Location/Address of Construction: VERMONT TRANSIT - 950 CONGRESS ST. PORTLAND

Proposed Project Description: (Please be as specific as possible)
HVAC UNIT REPLACEMENT

BUILDING PERMIT REPORT

REASON FOR PERMIT: Replace HVAC unit Dept.

JOB VERMONT TRANSIT

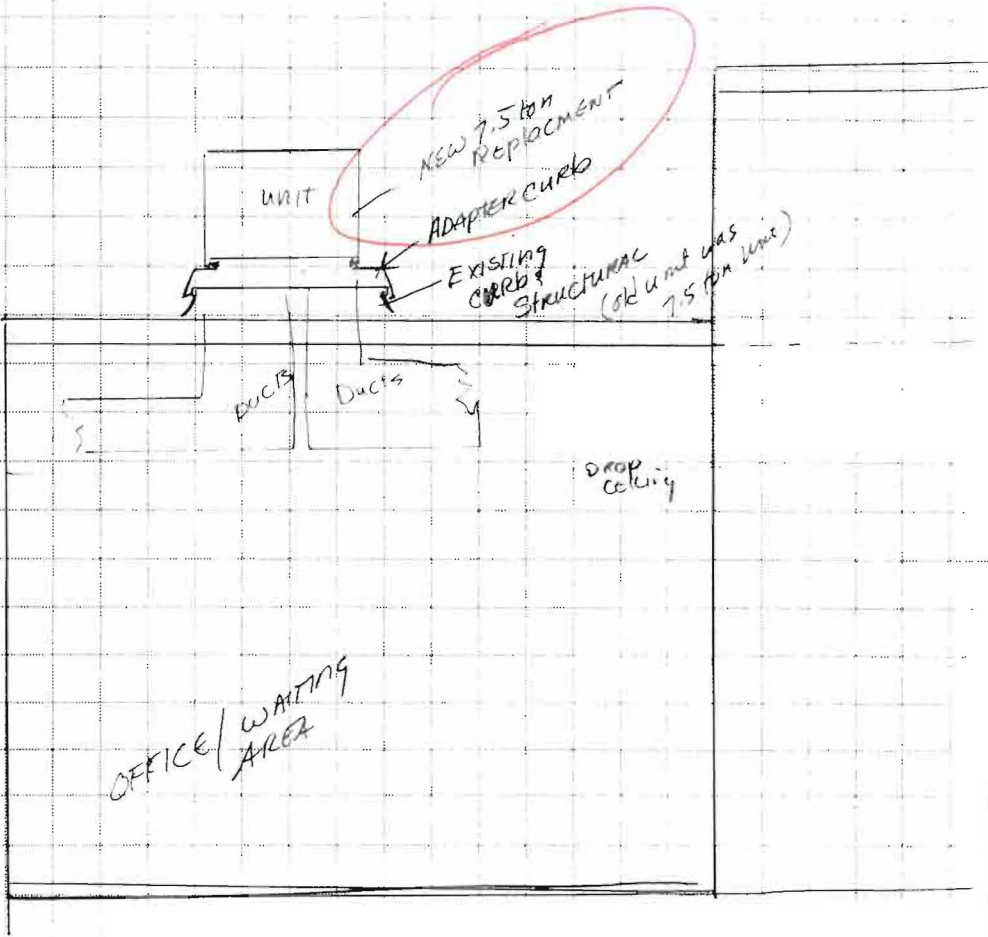
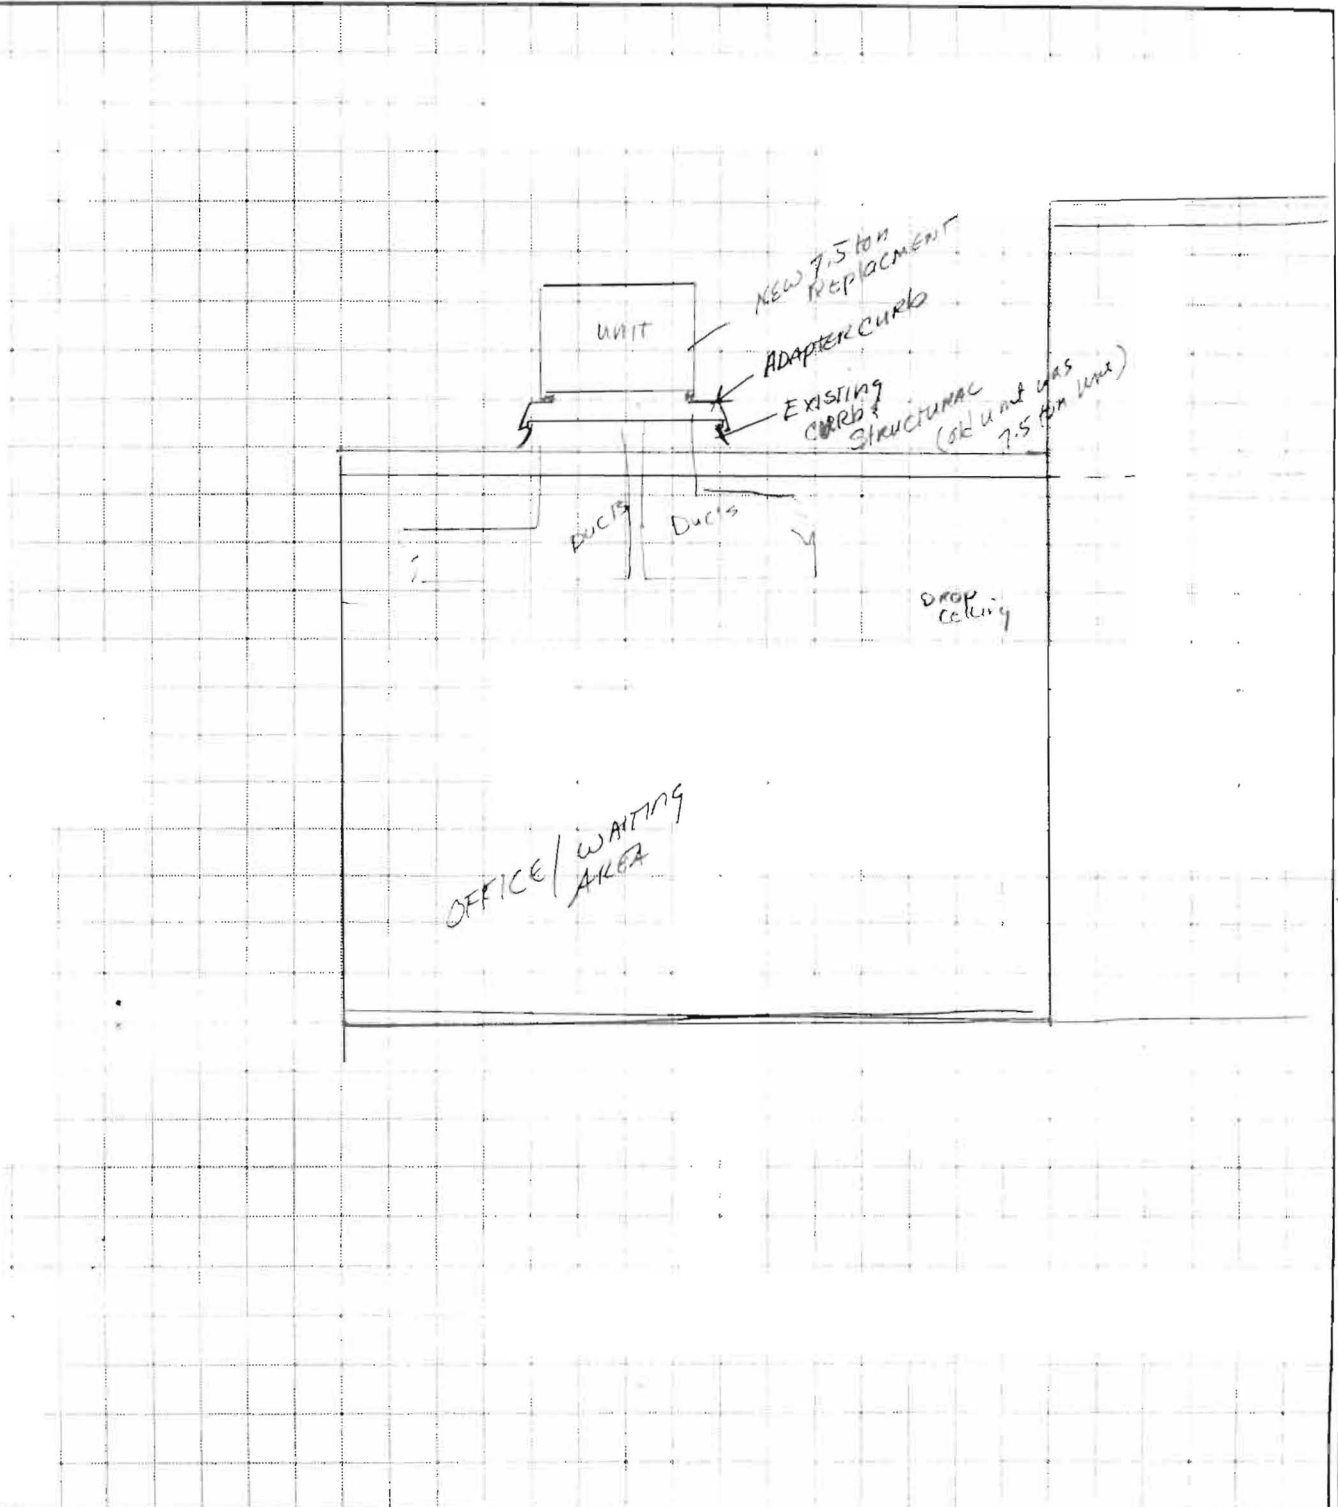
10/12/98 New unit is lighter than old unit
talked with Doug.

30. Glass and glazing shall meet the requirements of Chapter 24 of the building code.
- *31. I understand that this is a replacement unit. If the weight increases with the new unit, a structural analysis should be done of the roof system to verify the roof system can carry the new load.

11-4-98 New Unit weighs less than old unit
so roof should be adequate
for new unit OK
MW
